STRUCTURAL PERMIT CORRECTIONS

May 5, 2022

RE Permit corrections for Koneru Residence at 6610 E Mercer Way, Mercer Island, WA 98040, Permit No. 2112-250

We have received and reviewed the STRUCTURAL comments regarding the 6610 E Mercer Way project, permit number 2112-250. Below are the corresponding responses to the structural comments for the correction notice prepared by Crystal Kolke, Kolke Consulting Group, Inc dated April 12, 2022:

**A6**

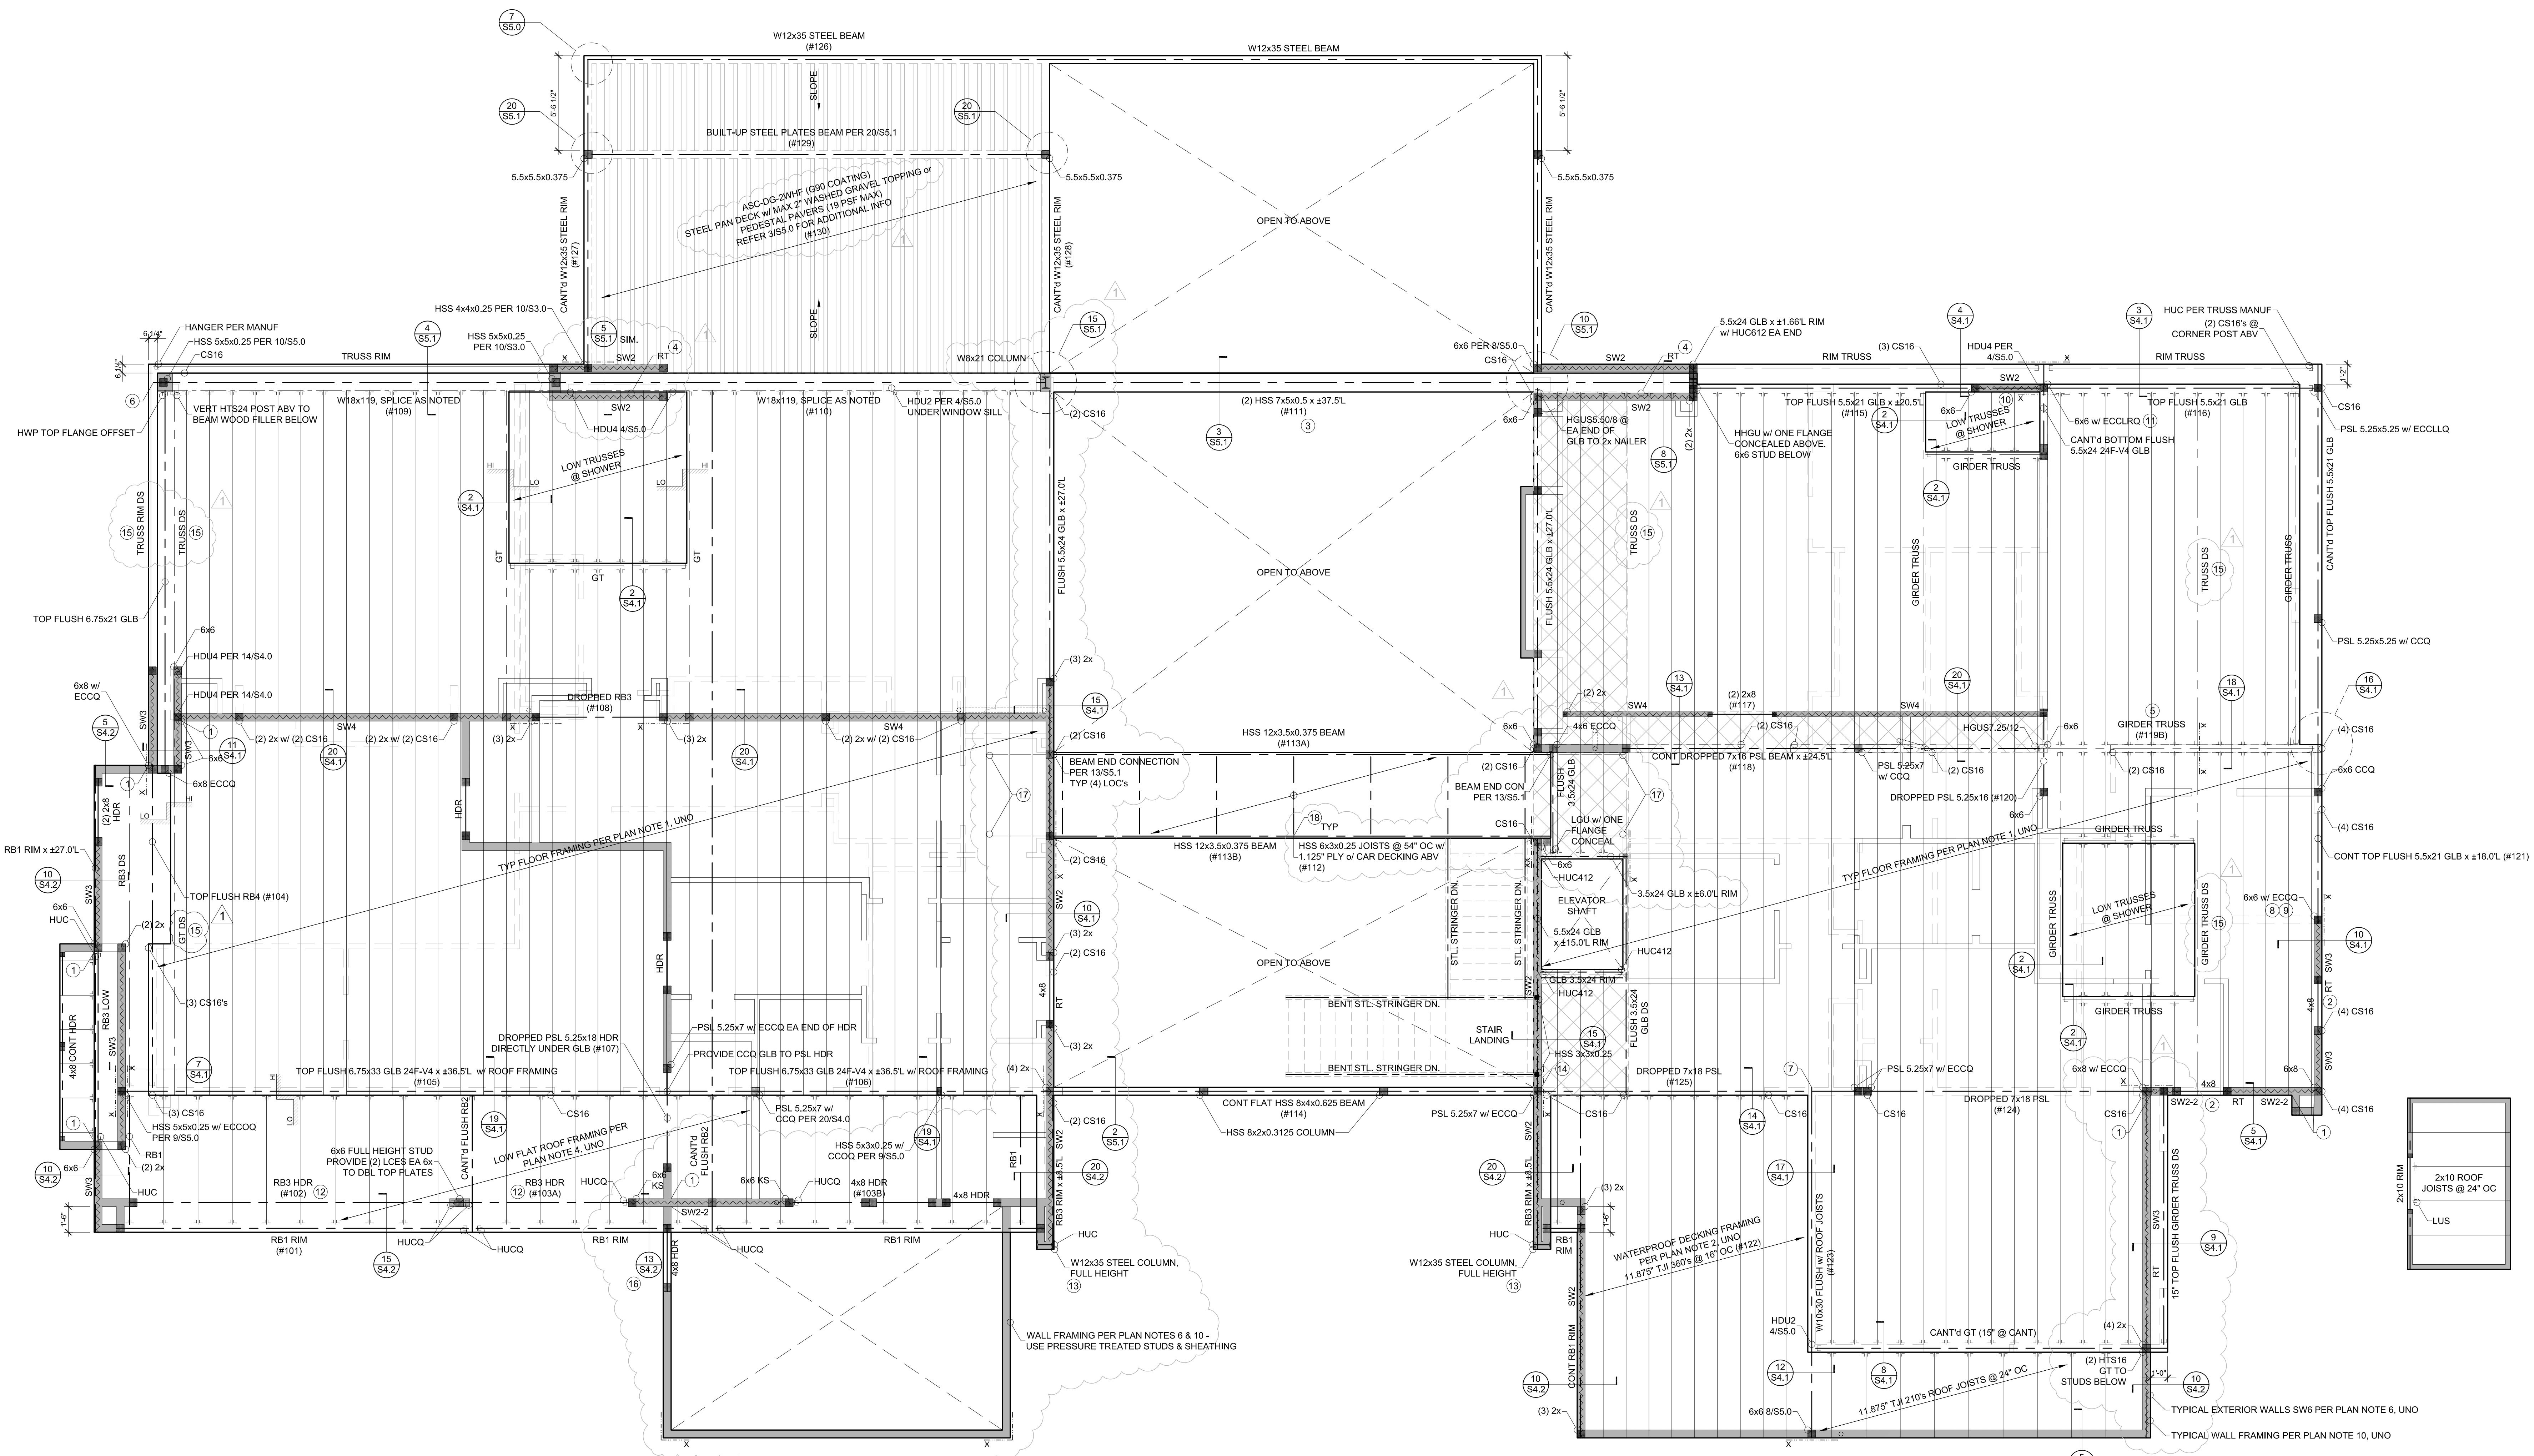
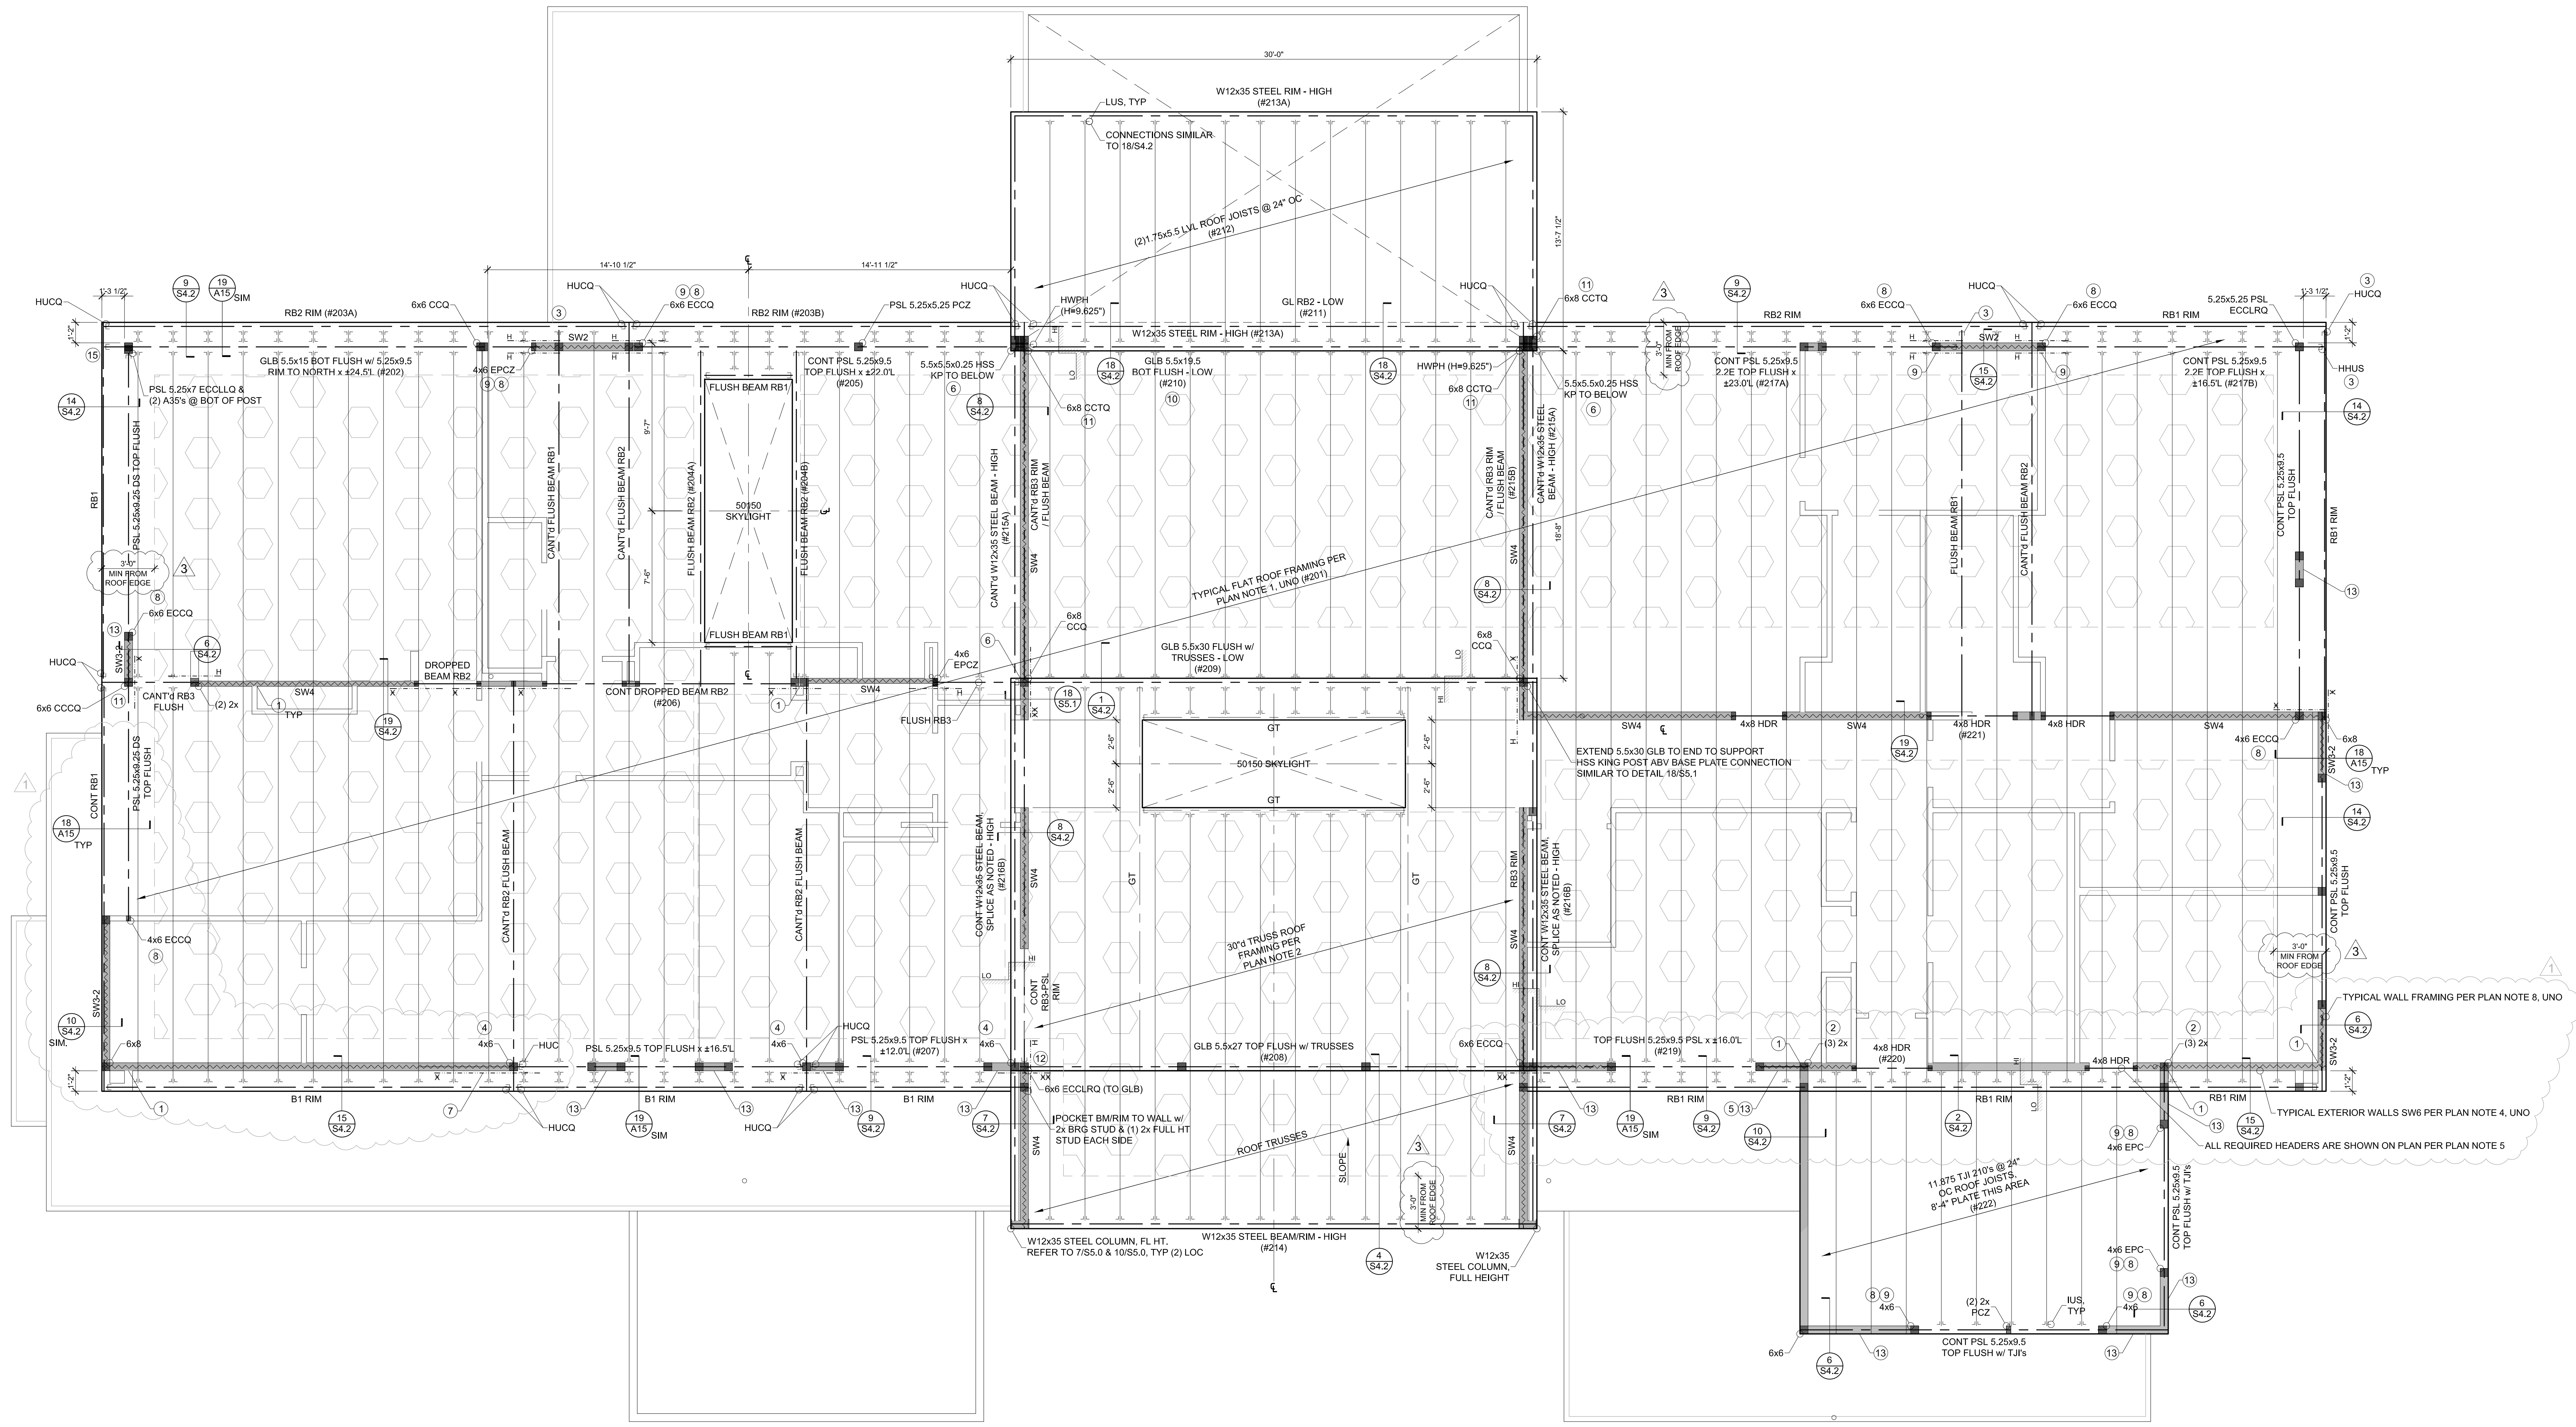
12. Grade beam over pin pile has now been added under bottom of stair.
13. Bridge beams will be supported by the flush glulam beam. Foundation grade beam has been added to support beam end reaction above and detail 13/S5.1 has been revised to show required beam end connections.
14. Pin piles supporting W8x21 column have now been revised.
15. Beam #121 - 5-1/2x21 is adequate to resist the design load, please see revised beam calculations.
16. ASC DG-2WHF steel pan deck roof over patio has now been called out on plan, please see revised plan on sheet A6.
